PLANNING AMENDMENT

APPLICANT NAME AND ADDRESS MR L SHEPPARDSON 21 RODERSGATE LUTON SPALDING Lincs PE12 9NN Telephone:	AGENT NAME AND ADDRESS JULIAN WARRICK 8 BEECH GROVE EDNINGTON Lincs PE11 4XD Telephone: 07849 652067
SITE ADDRESS DETAILS ADJ 17 TRAFALGAR SQUARE LEANS SUTTON SPALDING Lincs PE12 9HB	
CURRENT APPLICATION NO: This amendment cannot be considered unless the relevant reference is stated.	H11-0485-24
Building Regulation reference relating to same development (if applicable)

RESIDENTIAL DEVELOPMENT

J192-PL 3D

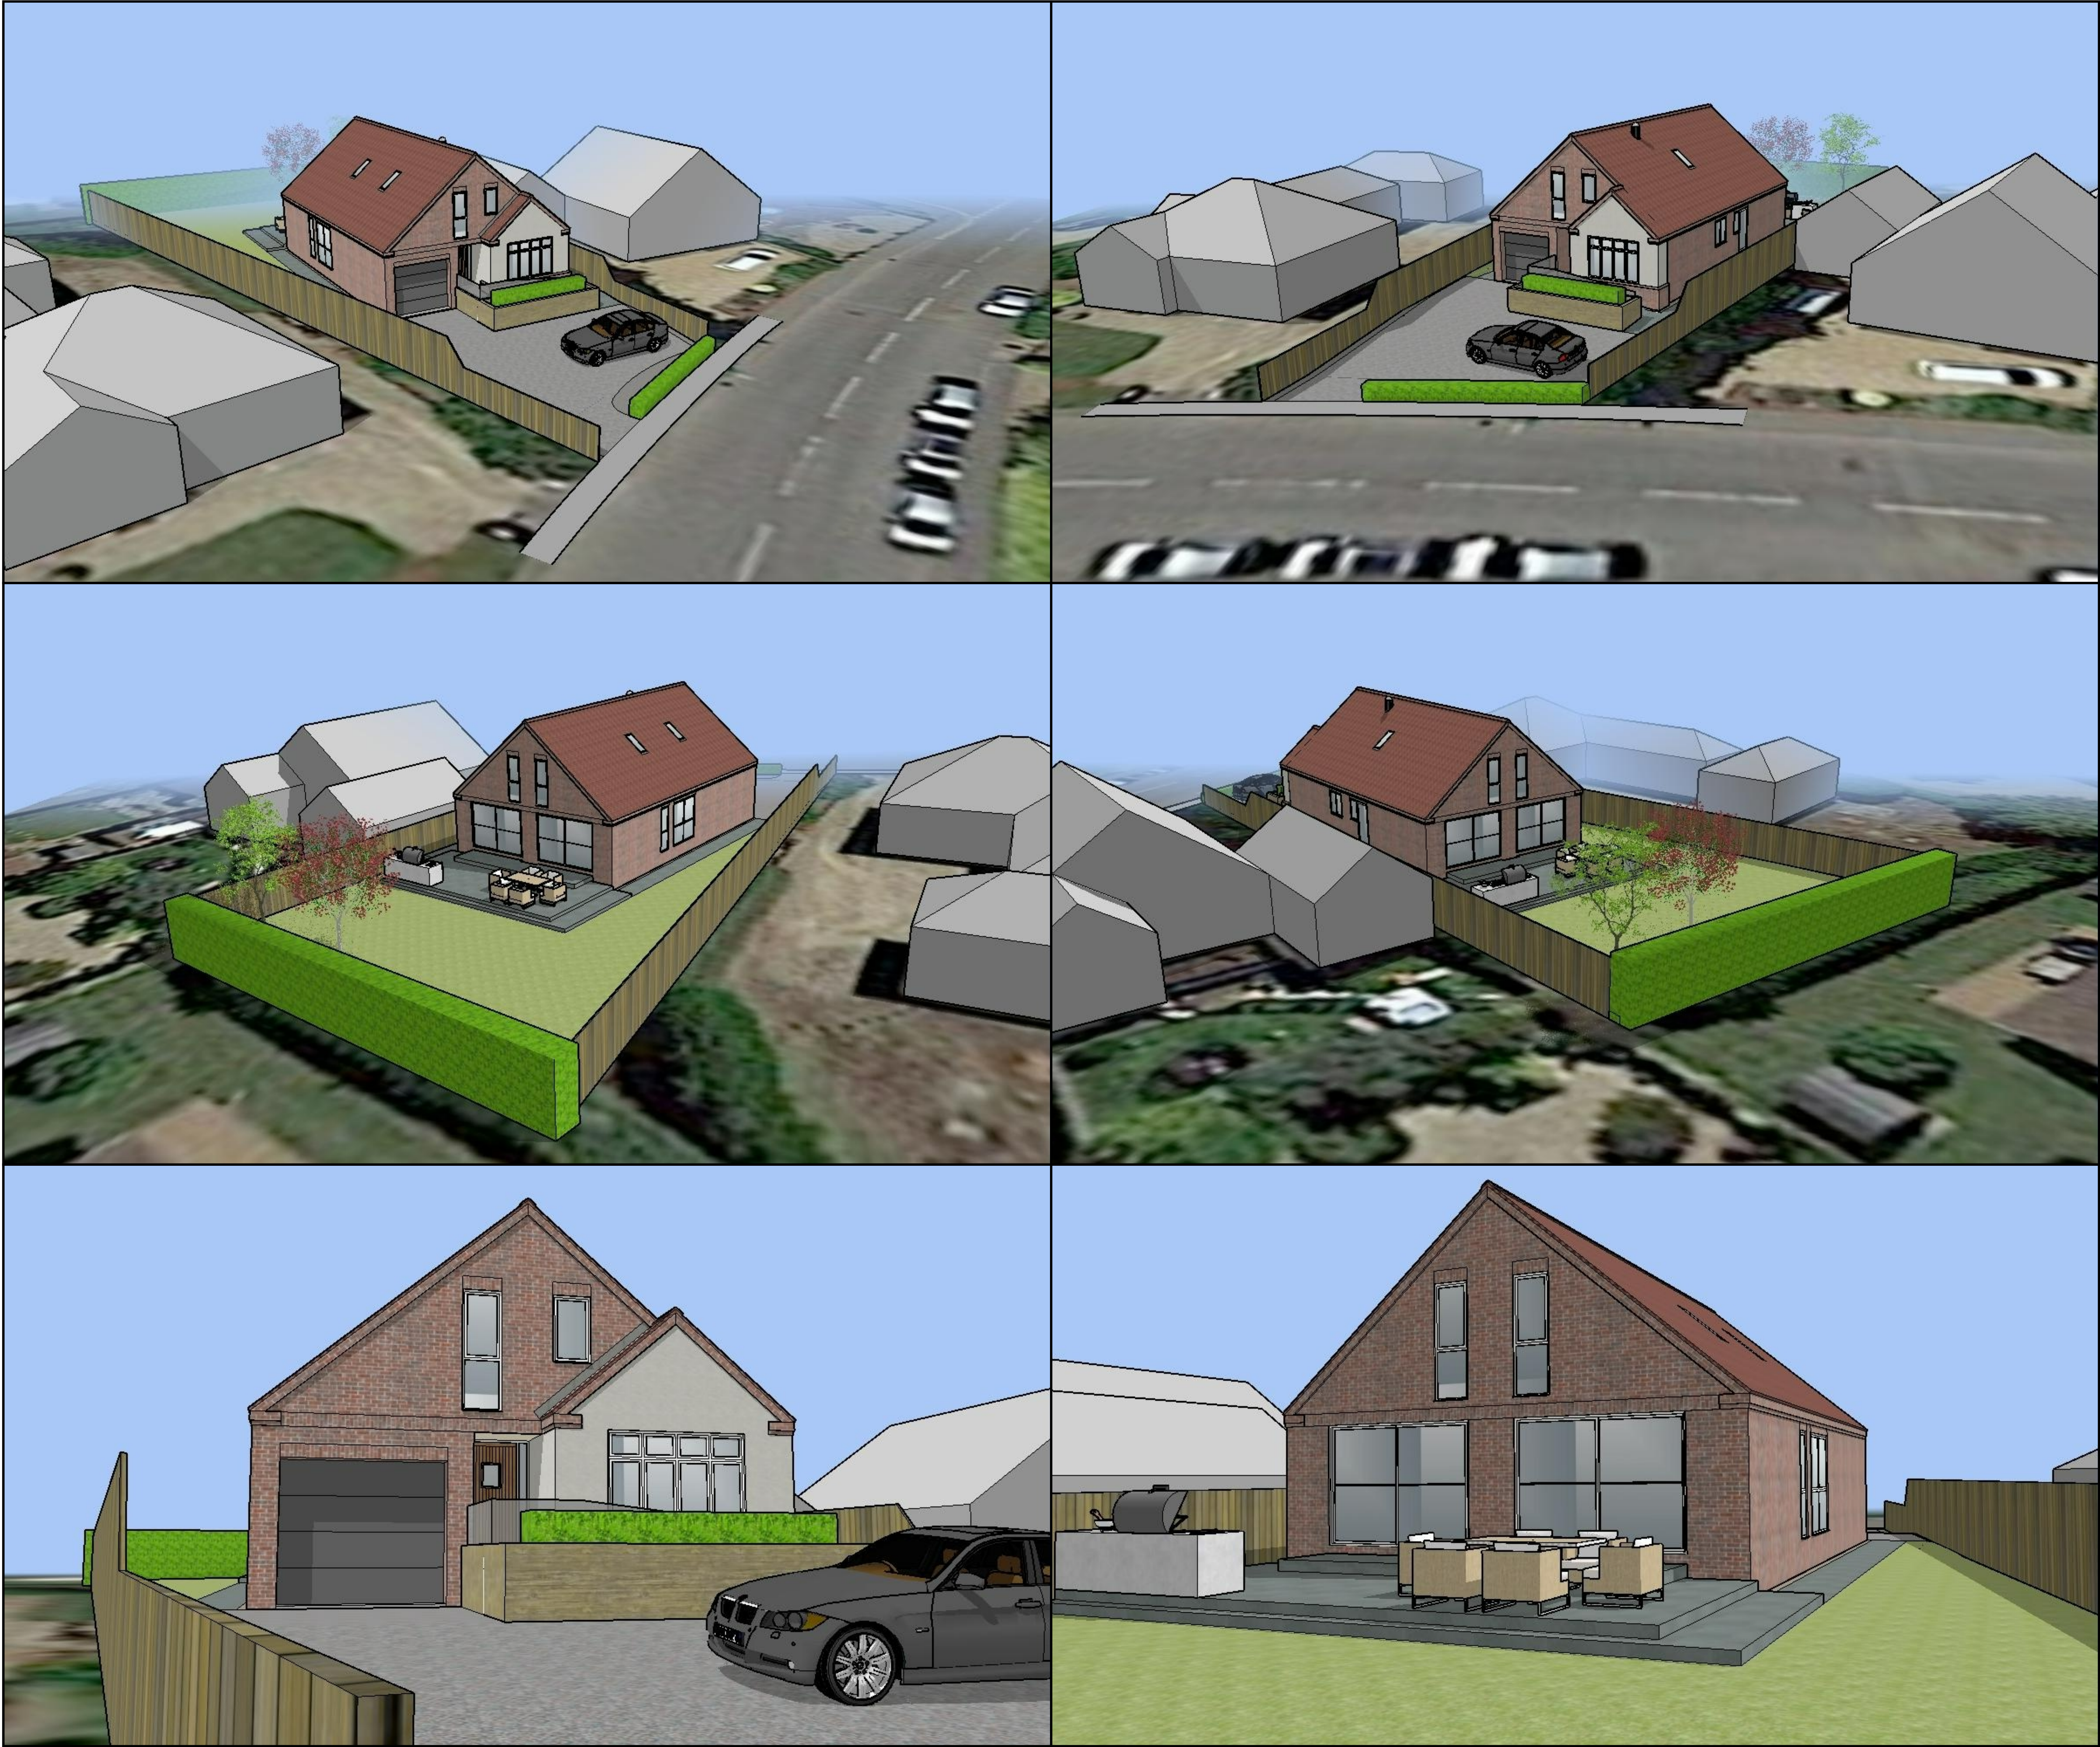
State details of amendments proposed. (Give a full detailed list of the changes, and also mark these clearly on the accompanying plans. Only the changes listed here will be considered)	HEIGHT OF BUILDING INCREASED TO SHOW FULL EXTENT OF FLOOD RISK REQUIREMENTS.	
State drawing numbers of the current submission	J192-PL1B, PL2A & PL3B	
Has this amendment been requested by the Council? (If so, state Officer dealing with the application)	YES/ NO	M KILAUD
Describe any part of the original development which is excluded by virtue of the amendment, and state any alteration to plot numbers		
Has a similar amendment been submitted under Building Regulations? (If so, state Building Control Surveyor dealing with application)	YES / NO
